Planning Services Sign Permit Review Form

Date of Submittal	Application Number	Applicant	Landowner
12/18/2023	SIGN2312-0251	Blashfield Signs Co Inc.	AGS Land LLC

Contact Person	Contact Number	Sign Location	PIN Number
Jan Wright	910-485-7200	Fairground Farms	1518-55-5233.000

**FAIRGROUND FARMS SUBDIVISION & RIGHT-OF-WAY DEDICATION**  
SUB2307-0003

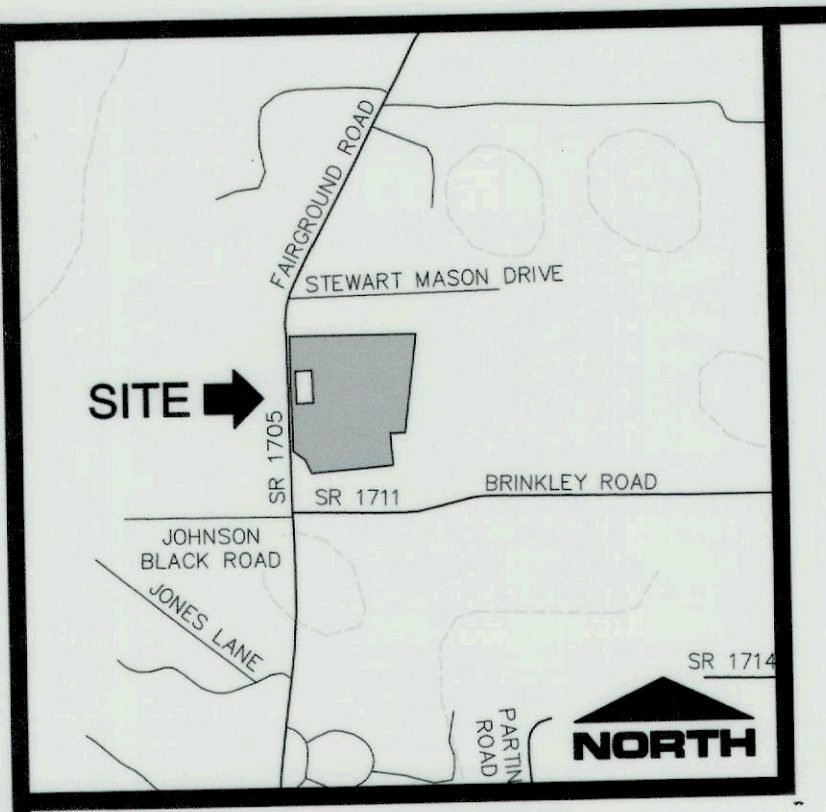
2. The location of the sign is not included on the site plan. Please show the proposed location of the sign and include the distance from the sign to each ROW. 20' from each ROW is required at intersections.

Sign

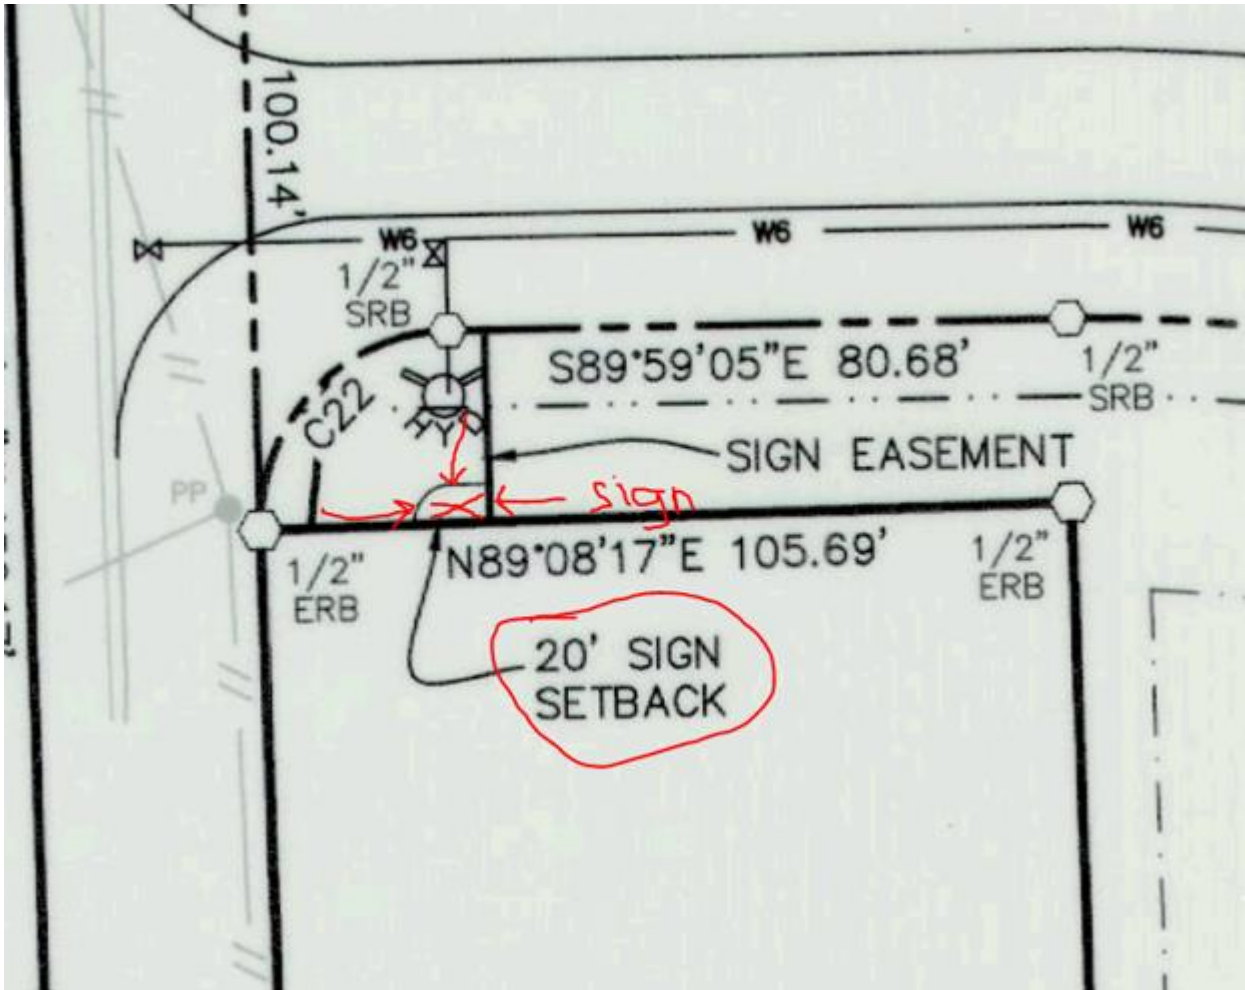
Comments	<p style="margin: 0;">10.6.1 Pole Style Ground Signs</p> <p style="margin: 0;">10.6.1 Pole Style Ground Signs</p> <p style="margin: 0;">All pole style ground signs with support(s), upright(s), bracing(s), or framework(s) that include a pole encasement shall meet the following requirements. Pole style ground signs for street signs, manufactured home park signs, interstate signs, historical identification signs, shall be exempt from the requirements of this Section.</p> <p style="margin: 0;">A. Said support(s), upright(s), bracing(s), or framework(s) shall be encased in an ornamental shell of stone, brick, ornamental metal, or similar materials, and shall be a minimum width</p>
----------	---

of one quarter ($\frac{1}{4}$) of the width of the sign face; or
B. Said sign shall be constructed of an external support structure including stone, brick, ornamental metal or similar materials, provided that the maximum number of supports, uprights, bracings, or frameworks extending between grade and the base of the sign face shall not exceed two (2).
